Alesco Senior College, Charlestown (SSD-10478)
Response to Submissions

Attachment A – Key Issues

Alesco Senior College, Charlestown (SSD-10478)

SEDIMENTATION AND EROSION CONTROL PLAN

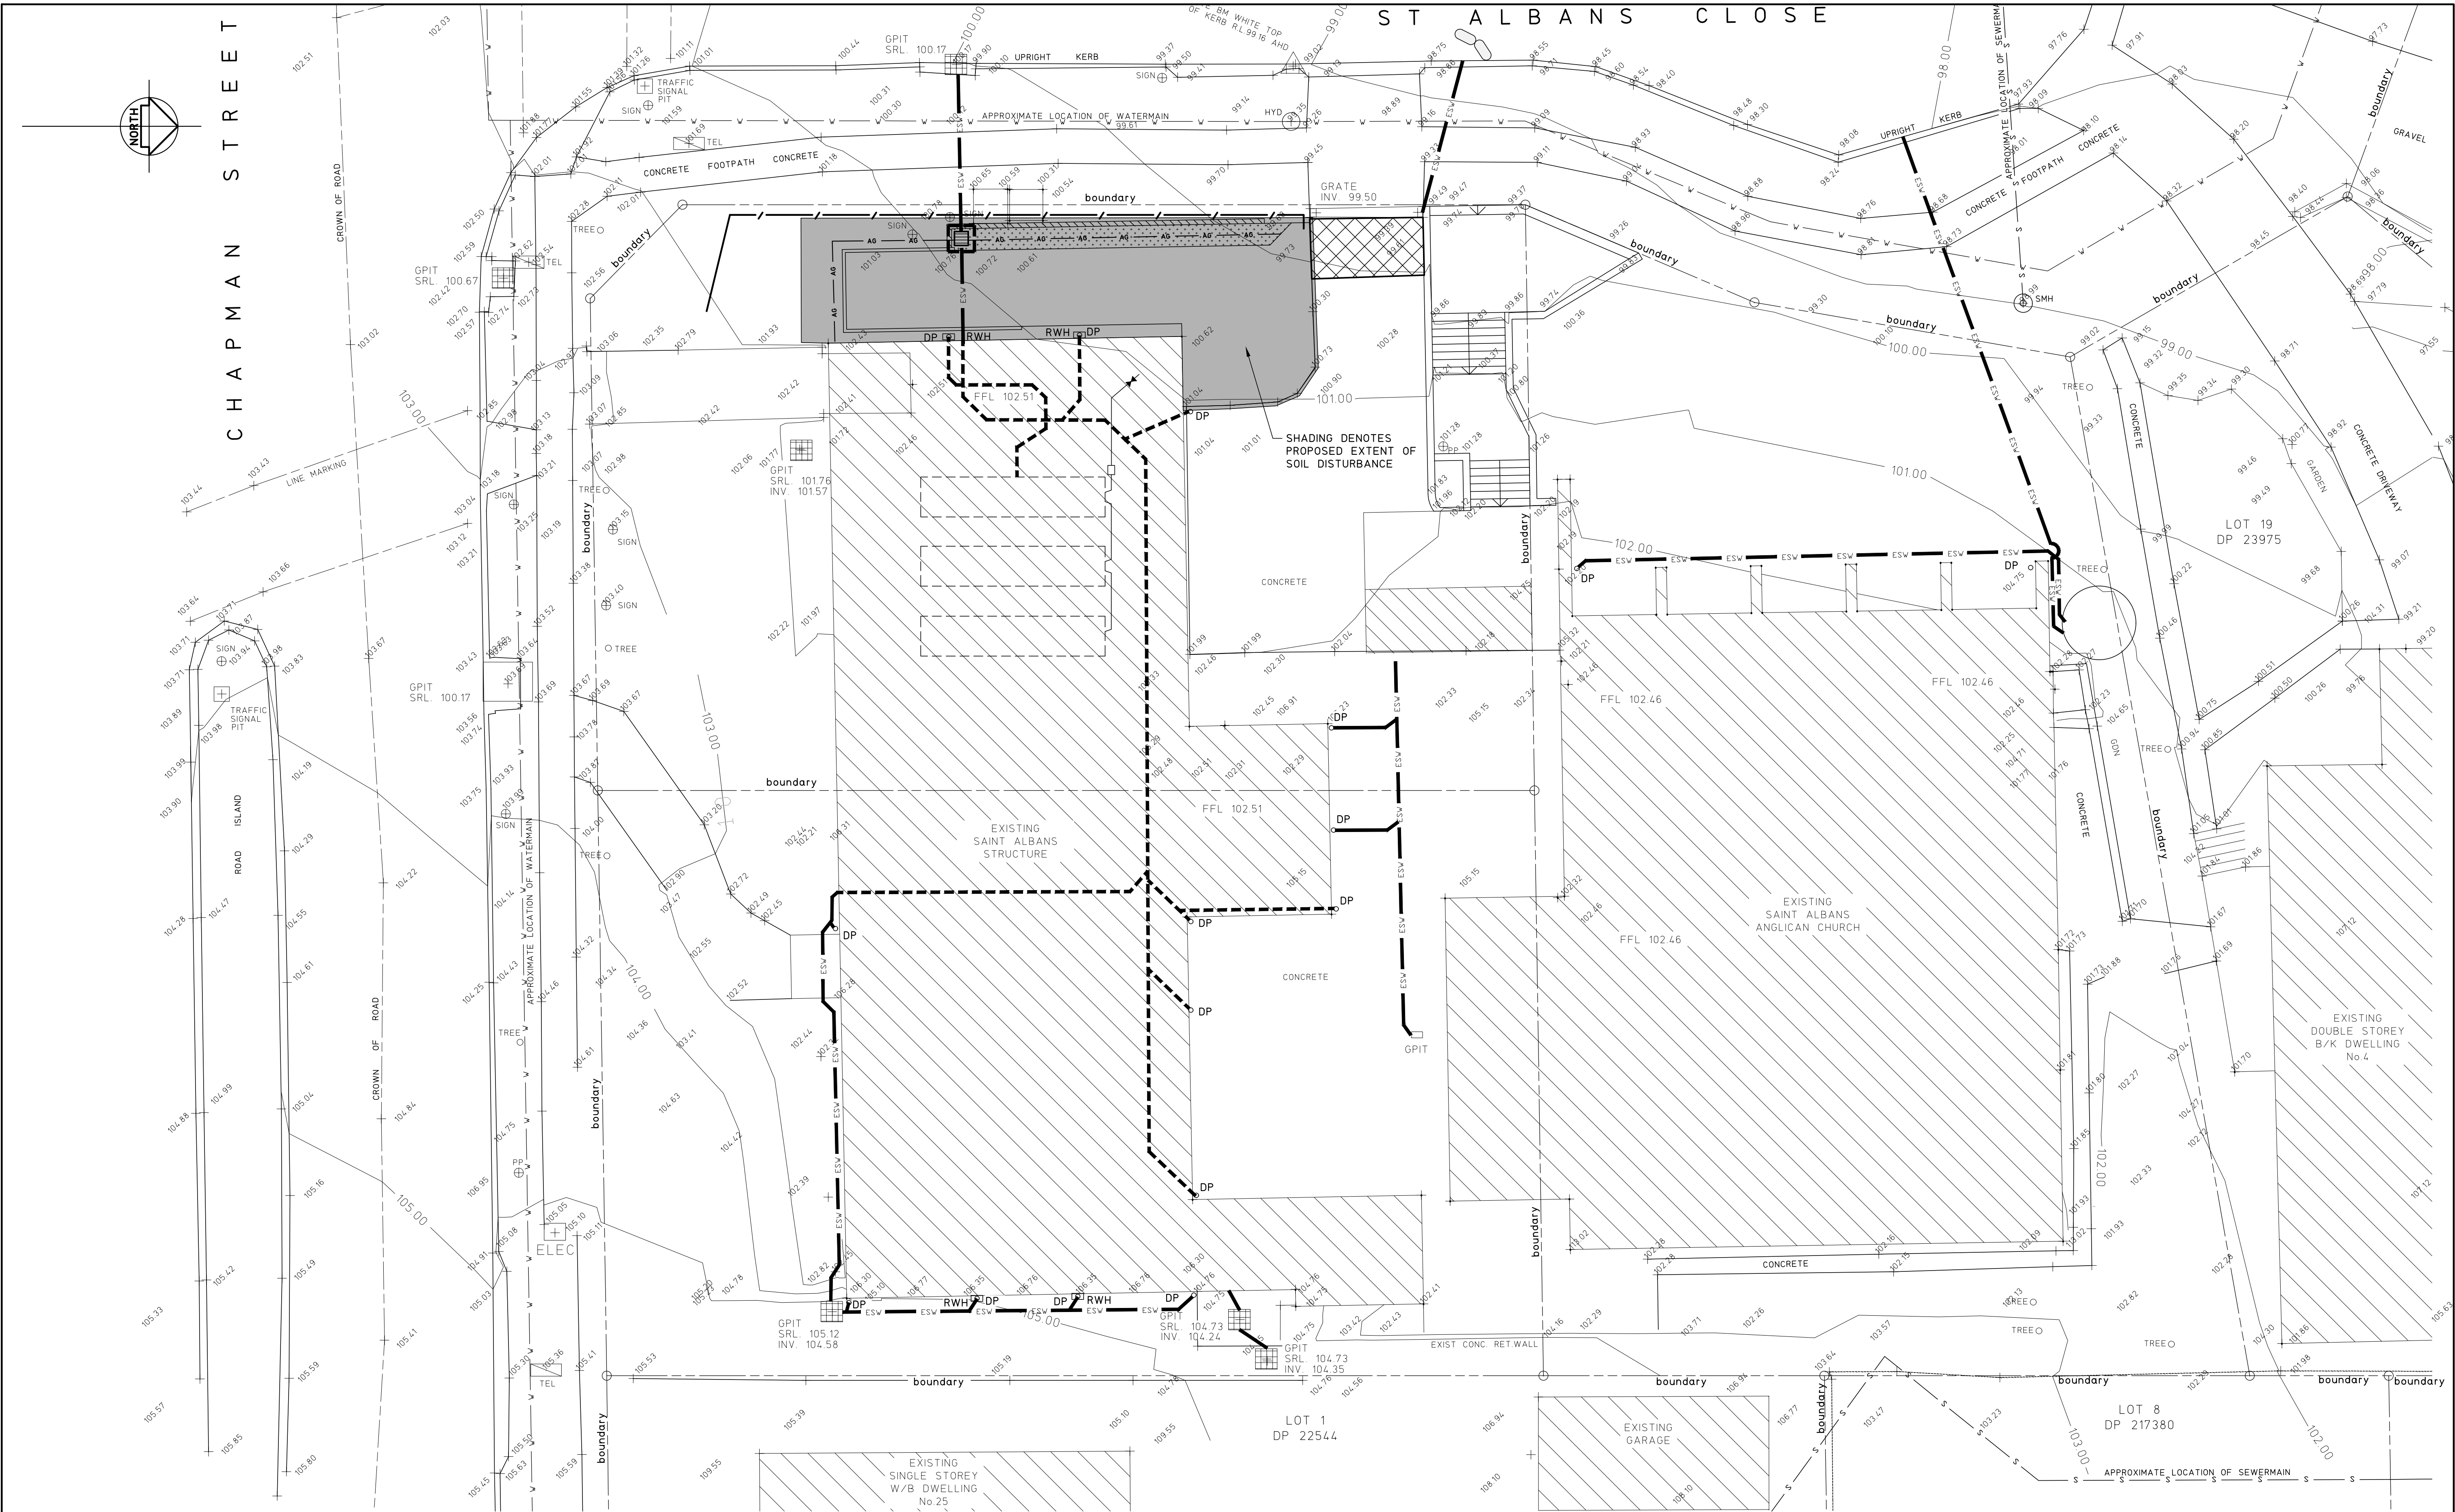
- The Environmental Impact Statement (EIS) states that earthworks are necessary to create a level building platform, associated car park and play areas and to meet accessibility requirements. Please detail the extent of earthworks proposed to be carried out on the site and provide an Earthworks Plan that outlines the extent of cut and fill volumes.
- Provide final proposed levels in relation to current levels on the site and adjoining sites, including long sections through the site.
- Confirm whether the disturbed soils would be re-used on the site (i.e. for landscaping) or whether soils would be required to be disposed of off-site.
